Kate MacDonald - RE: SSD 5894 - Barangaroo Remediation Works - Block 4

Please find below commentary from the City's Health and Building Unit regarding the Barangaroo remediation application.

Air Quality Impact Assessment (AQIA).

Figure 3 Indicative Stack Locations

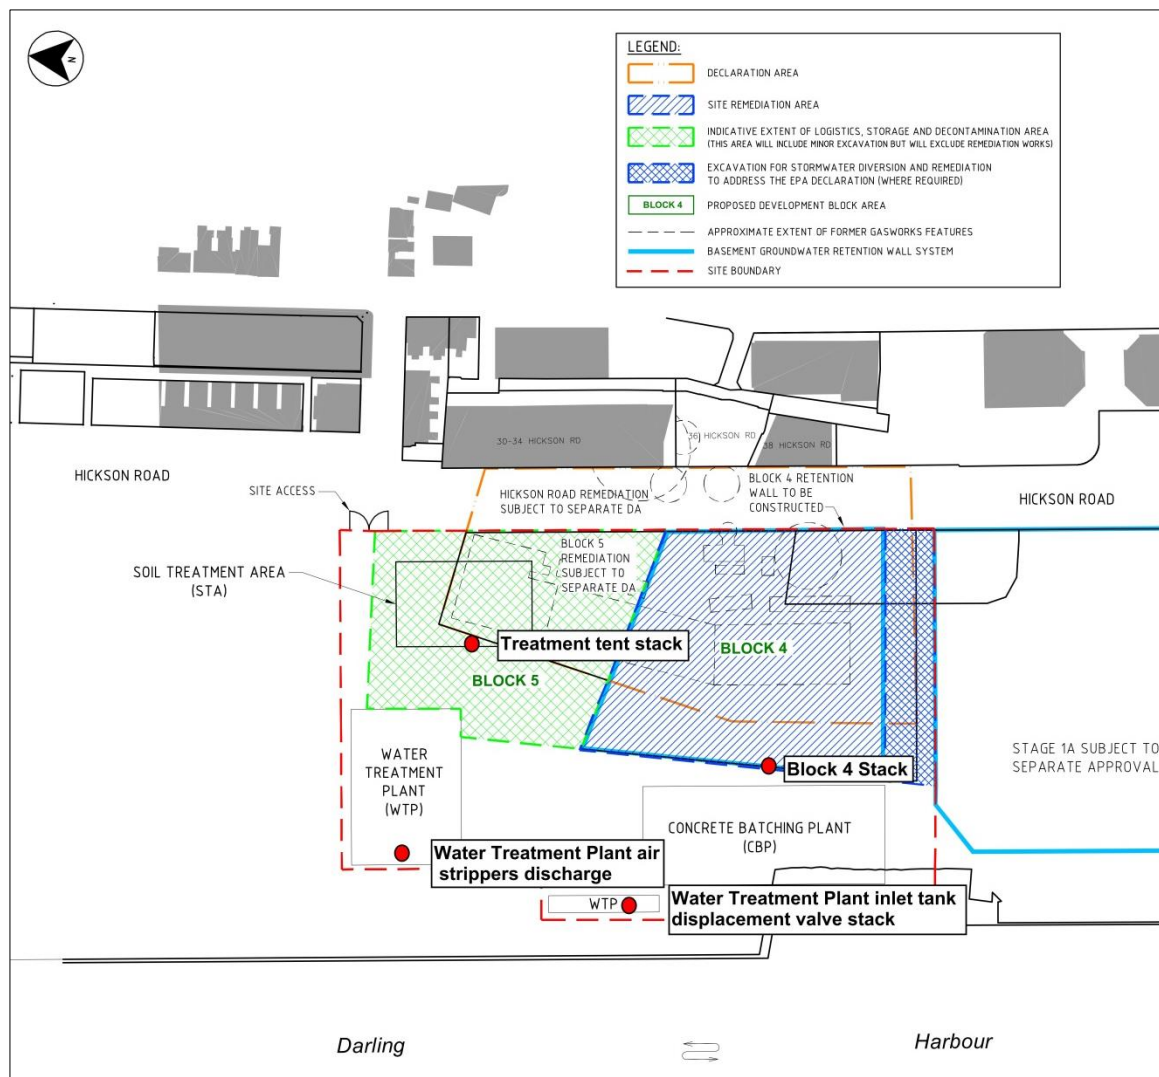
- 1. It is unclear as to the exact location and the actual number of OCSs to be installed. It is considered that the AQIA cannot be relied upon whilst the emissions from OCSs are not quantified and the exact location is not identified. The location of the soil treatment area in Figure 3 of the AQIA is not considered ideal with respect to the sensitive receivers, which includes a child-care facility.*
- 2. It is unclear as to the height of the ventilation stacks for the OCSs and how these relate to the up-gradient sensitive receivers, including residents on Hickson Road. It is suggested that cross-sectional diagrams could demonstrate proposed plumes from predominant air movement/ wind at the site.*

These issues and issues raised through the EPA document should be addressed through an amended AQIA.
